Appeal Decision

Appeal Ref: APP/R4408/W/21/3287058

R/O No 109 Barnsley Road, Wombwell, Barnsley S73 8JH

- The appeal is made under section 78 of the Town and Country Planning Act 1990 against a failure to give notice within the prescribed period of a decision on an application for planning permission.
 - The appeal is made by Mr Philip Pearce against Barnsley Metropolitan Borough Council.
 - The application Ref 2021/0791, is dated 23 May 2021.
 - The development proposed is a new bungalow.
-

ELEVATIONS @ 1:100M.

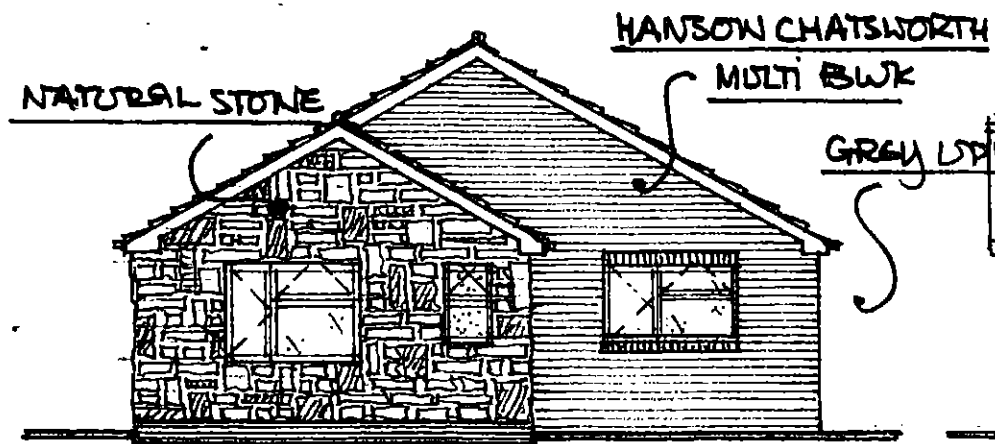
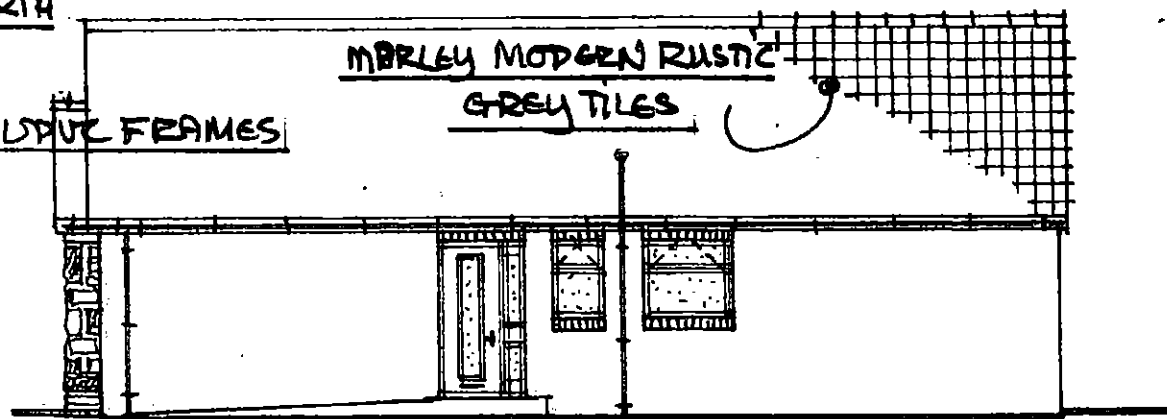
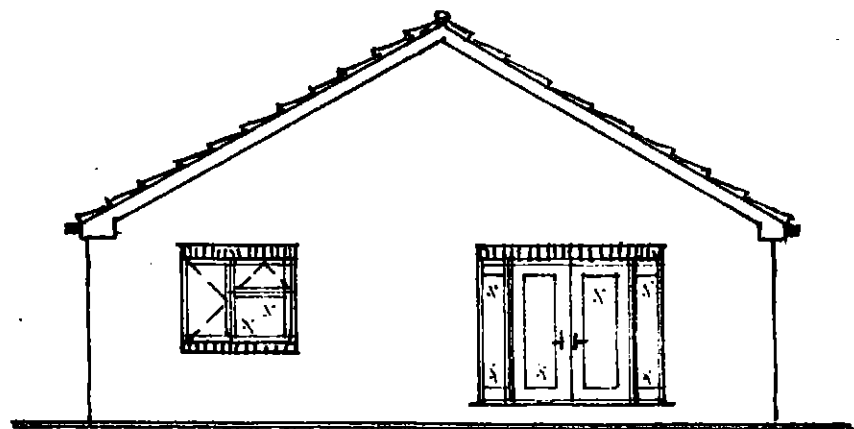
5. The proposal would consist of the construction of a new two to three bedroom bungalow with a 30 degree pitched roof. It would be accessed along John Close and would have a front parking and turning area.

10. In relation to future occupiers, due to the elevated level of the existing properties' first floor windows, based on my site visit, overlooking of the boundary wall from Nos 107a, 109 and 111 into the proposal's front area and front windows would be possible. Details of the first floor rooms and separation distance have not been confirmed, however, in all likelihood many of these would be habitable rooms and sufficiently close to allow overlooking with associated loss of privacy to the future occupants. In this case, provision of the recommended separation distances as set out in the SPD and the SYRDG would be required to prevent harm.

11. Whilst the front separation may not be sufficient to prevent harm from overlooking, it would be sufficient to prevent the existing properties being overbearing. With the gap between 107a and 109, the proposal's front outlook would be reasonably open. There would therefore, not be an unacceptable impact on the outlook enjoyed by the future occupiers.
12. In conclusion, while I do not find harm to the living conditions of the future occupants of the proposal with respect to outlook, I do find potential harm to privacy. This would be contrary to Policy GD1 of the Local Plan and guidance within the SPD and SYRDG. This policy and guidance, amongst other matters, seeks to ensure new development makes a positive contribution and does not adversely affect living conditions of future residents.

FLOOR LAYOUT @ 1:50M.

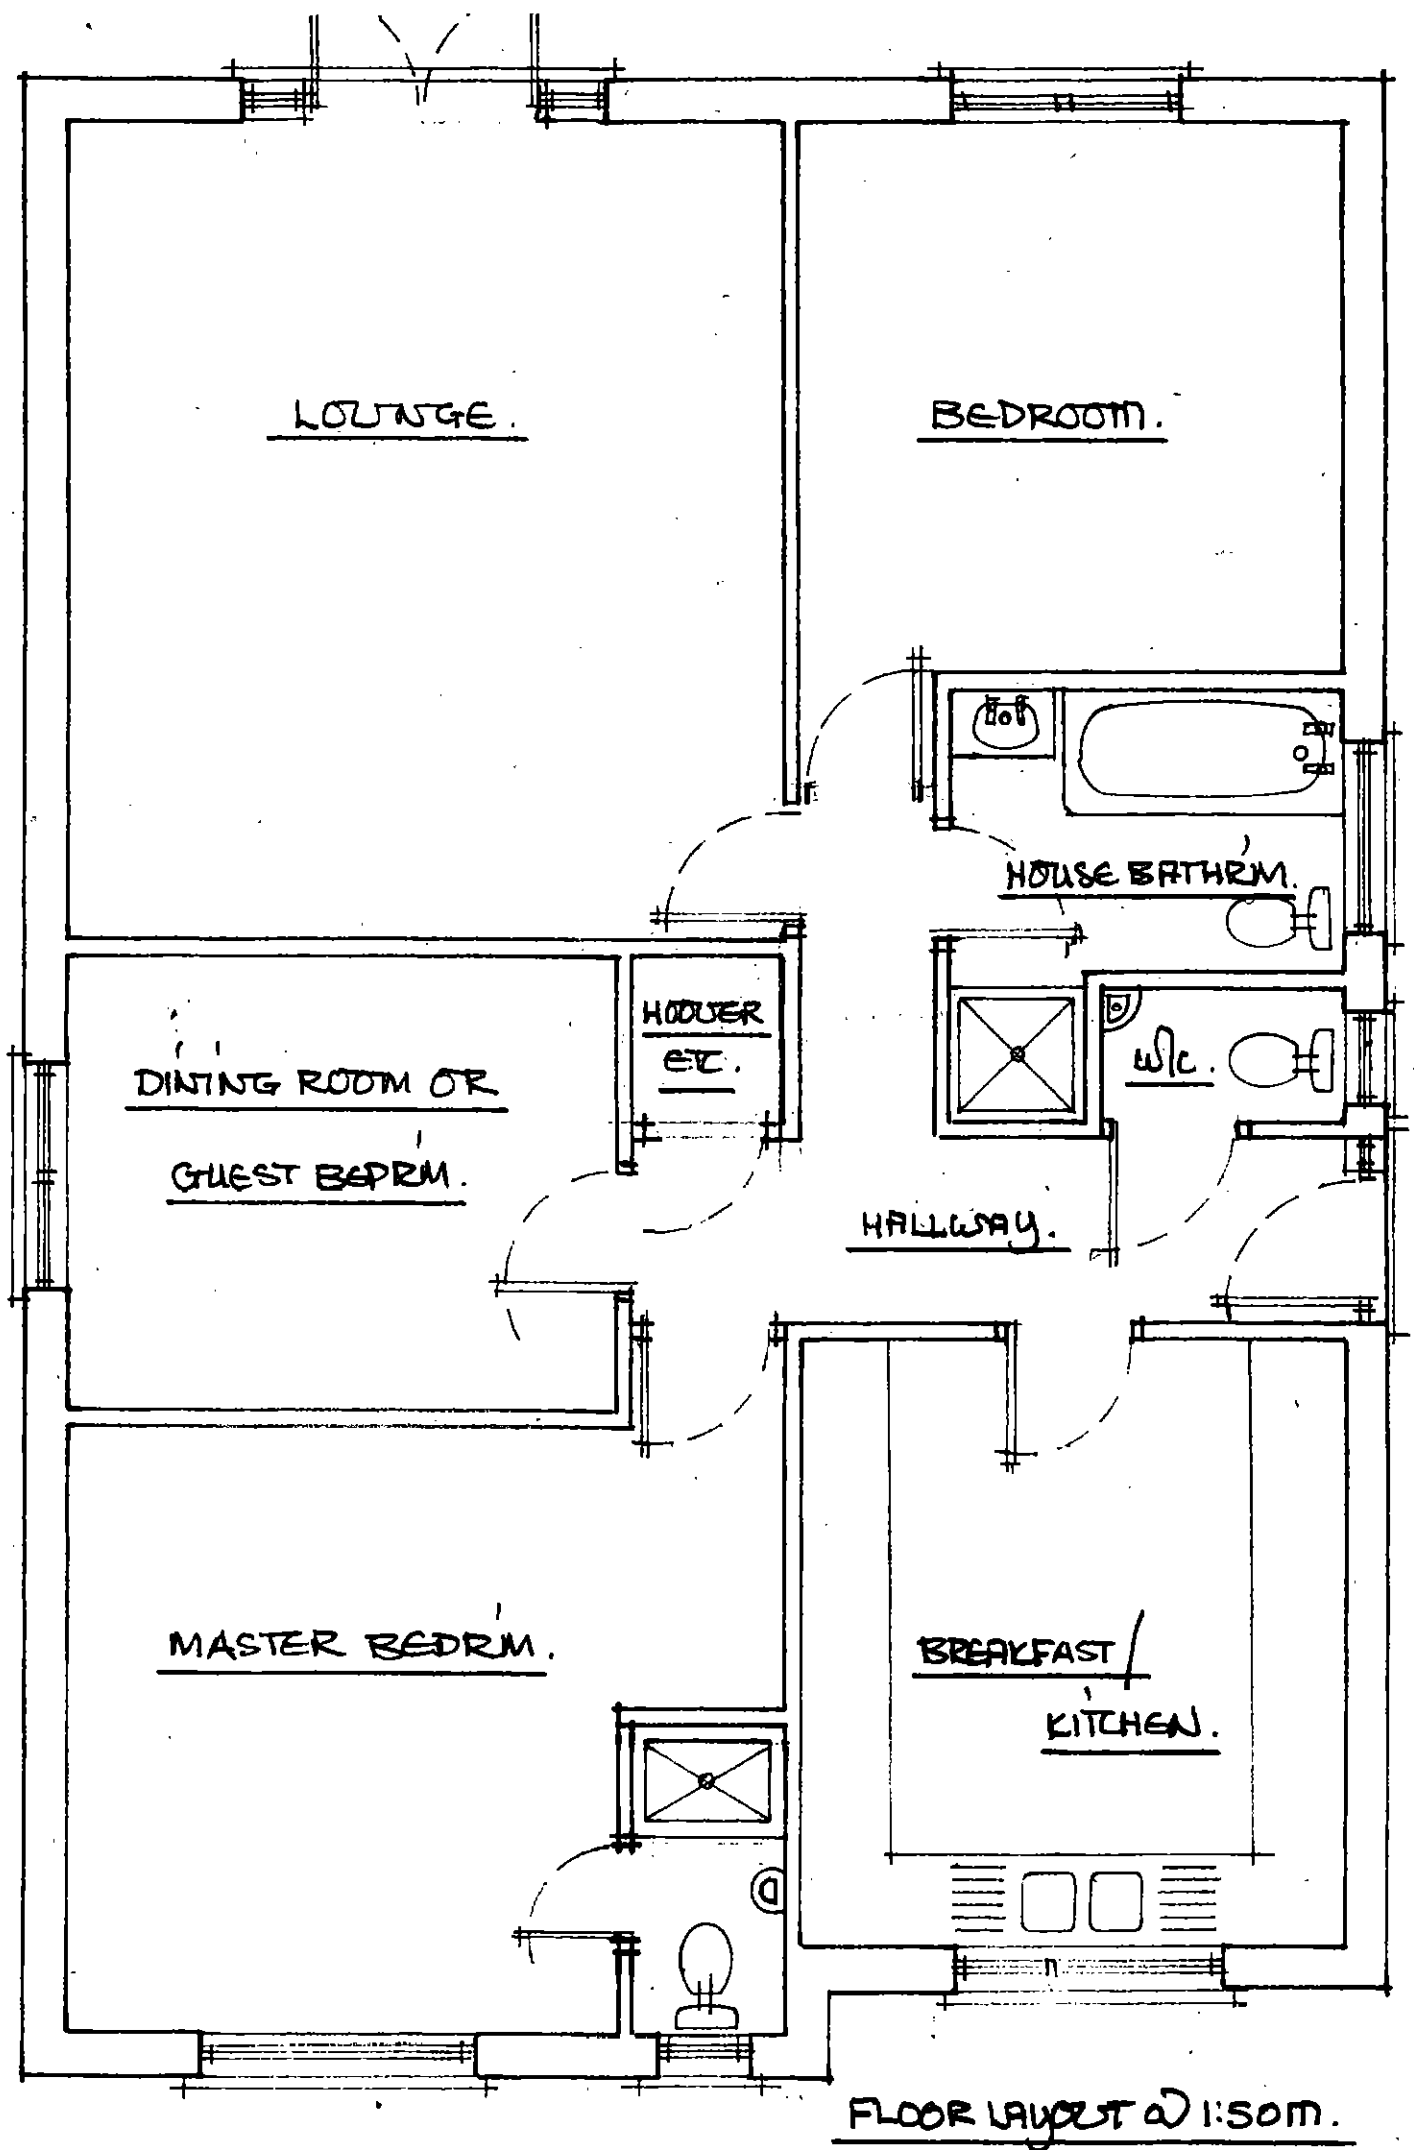
7. Although the proposal would be quite a modest addition, the introduction of parking to its front would result in an increase in the residential activity and vehicular movements close to the rear of the existing properties and adjacent gardens. This would result in an associated increase in noise and disturbance to this relatively quiet rear area of the houses. This would harm the living conditions of the occupiers of the existing properties.
